memorandum

date May 5, 2021

subject Review of 5637 East Mercer Way (MI Treehouse, LLC) – Reasonable Use Exception and Variance Applications (CAO15-001 and VAR18-002)

SCALE 1"=5'

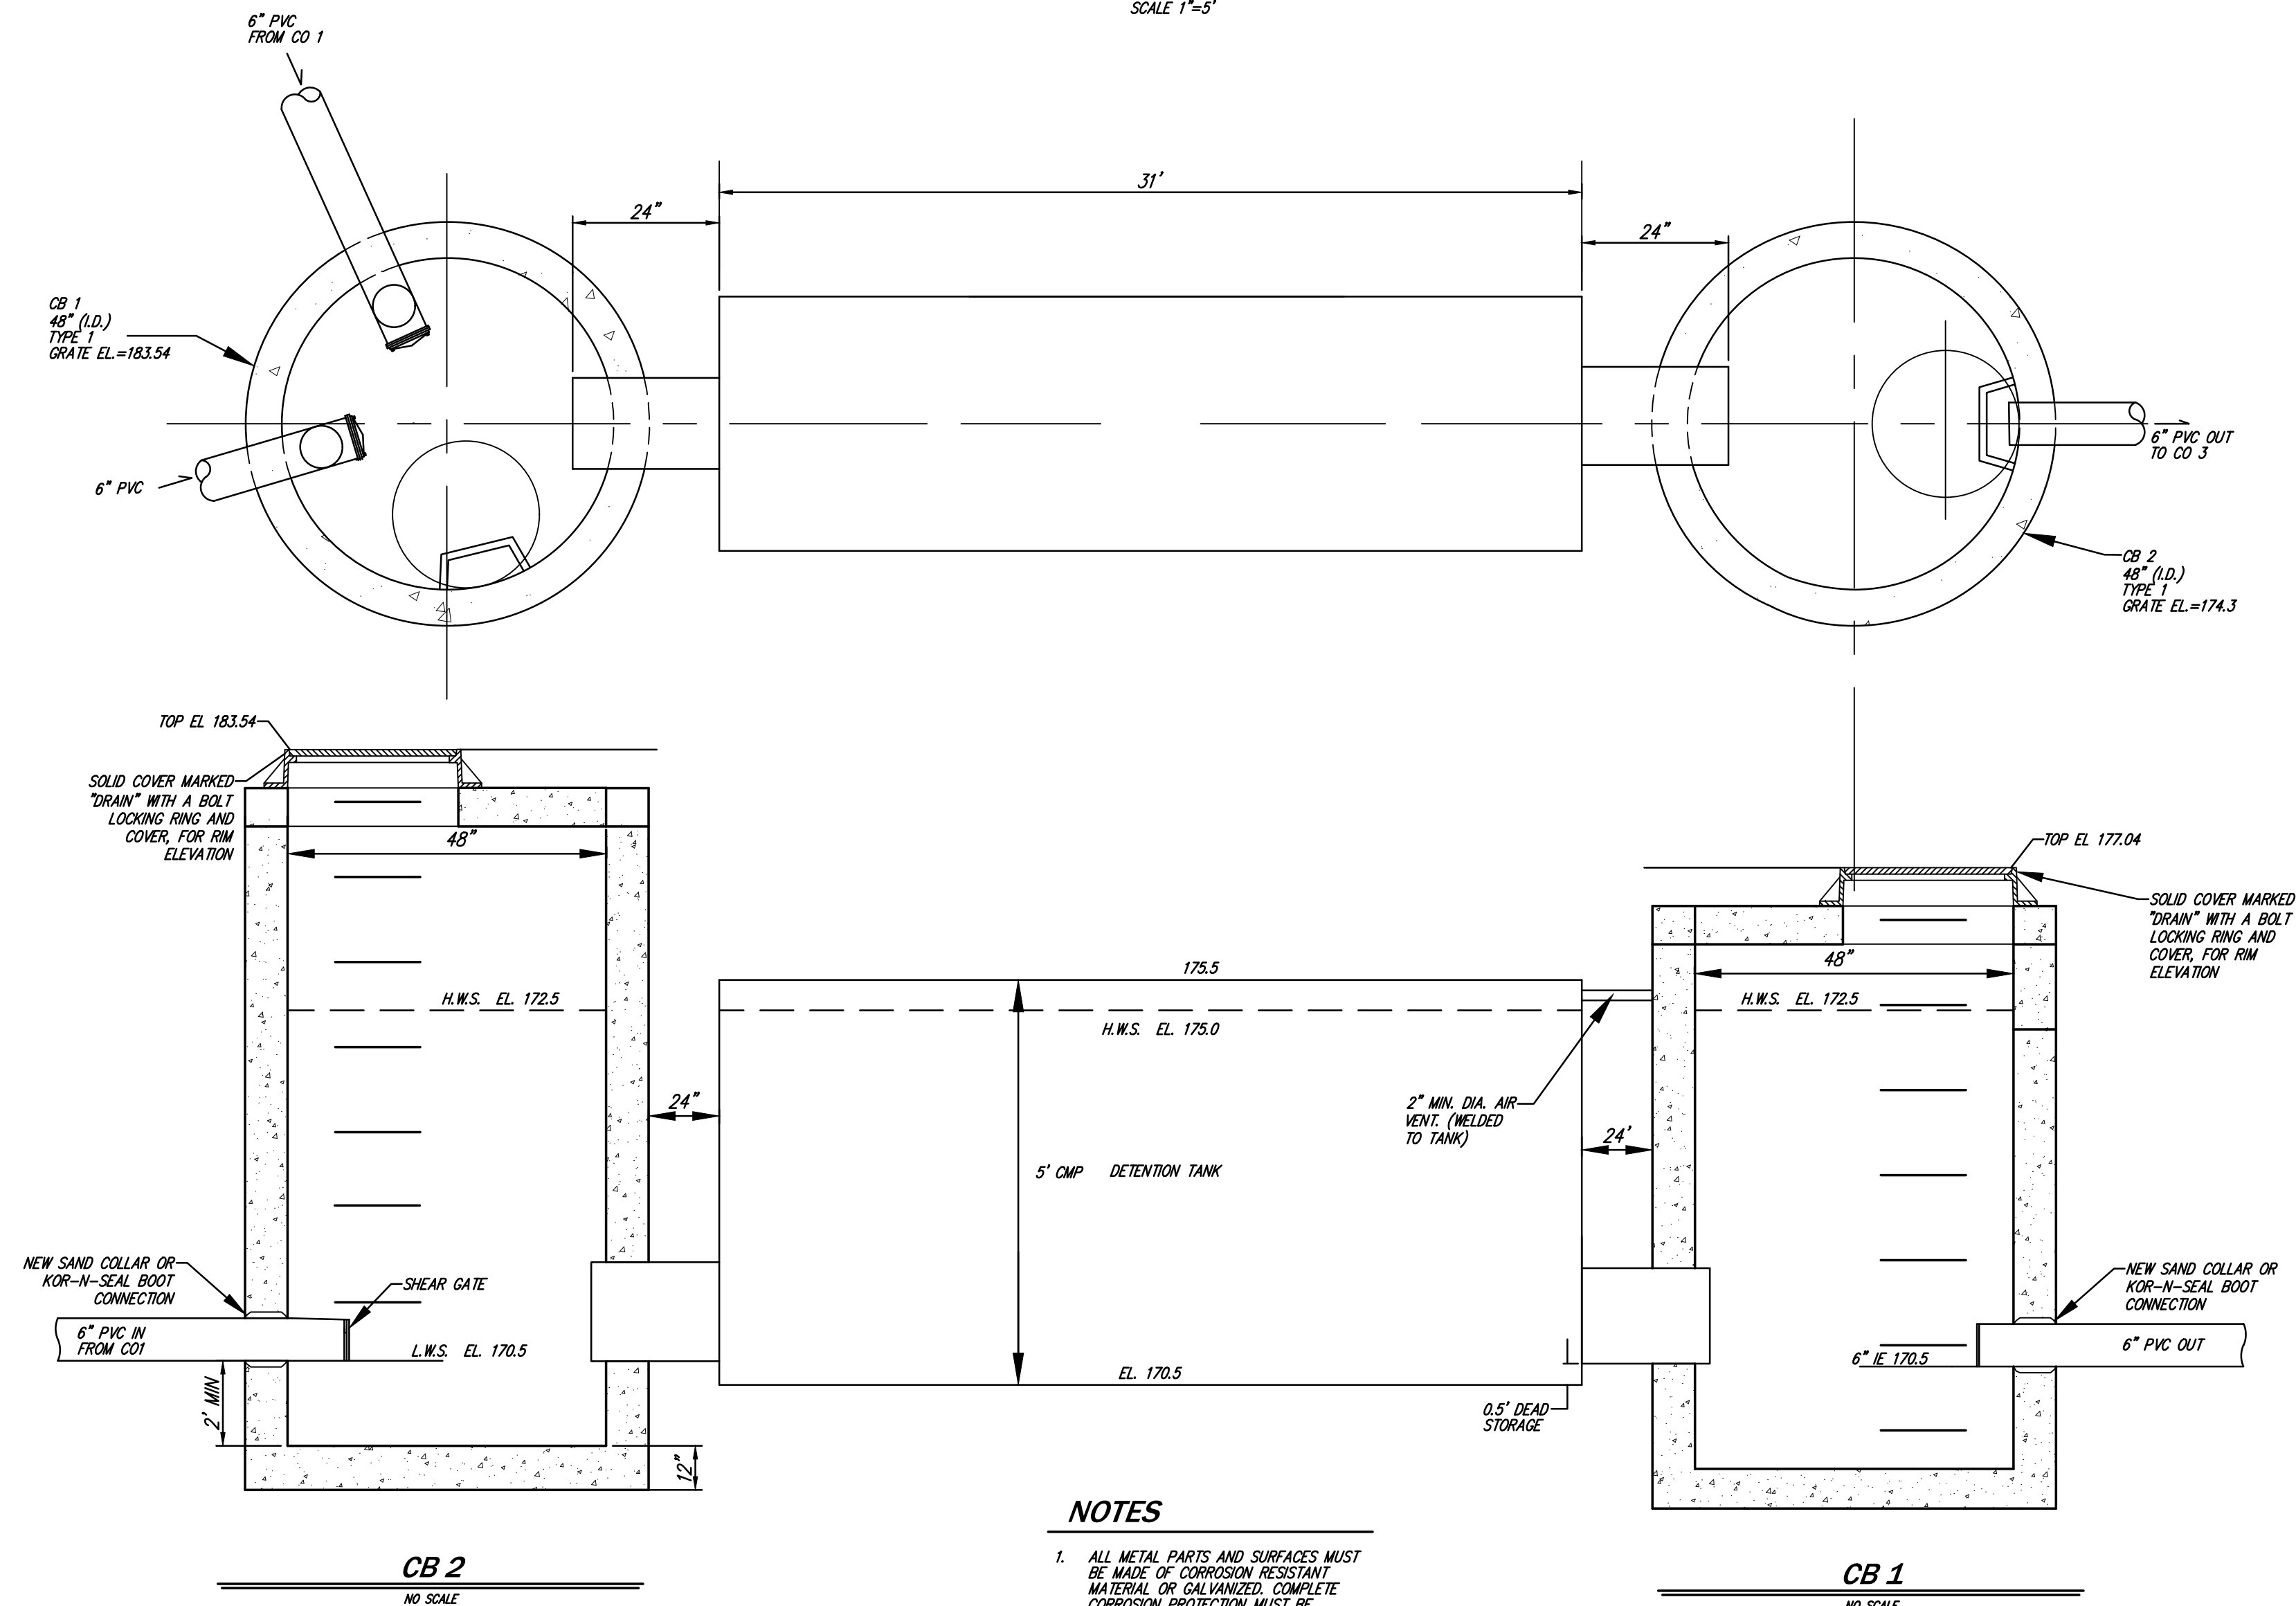
The revised site plan no longer depicts a retaining wall located west and southwest of the proposed residence. ESA previously commented on the wall and associated grading for the building foundation and potential impacts to wetland hydrology. **ESA seeks clarification for the current lack of grading within the slope wetland to accommodate the structure.** If grading is still required, ESA continues to recommend the applicant provide additional details about the onsite drainage system and how it will operate to not artificially drain wetland areas. Alternatively, the applicant can propose an offset from the drainage system that would account for lost wetland hydrology and mitigate impacts through additional credit purchase.
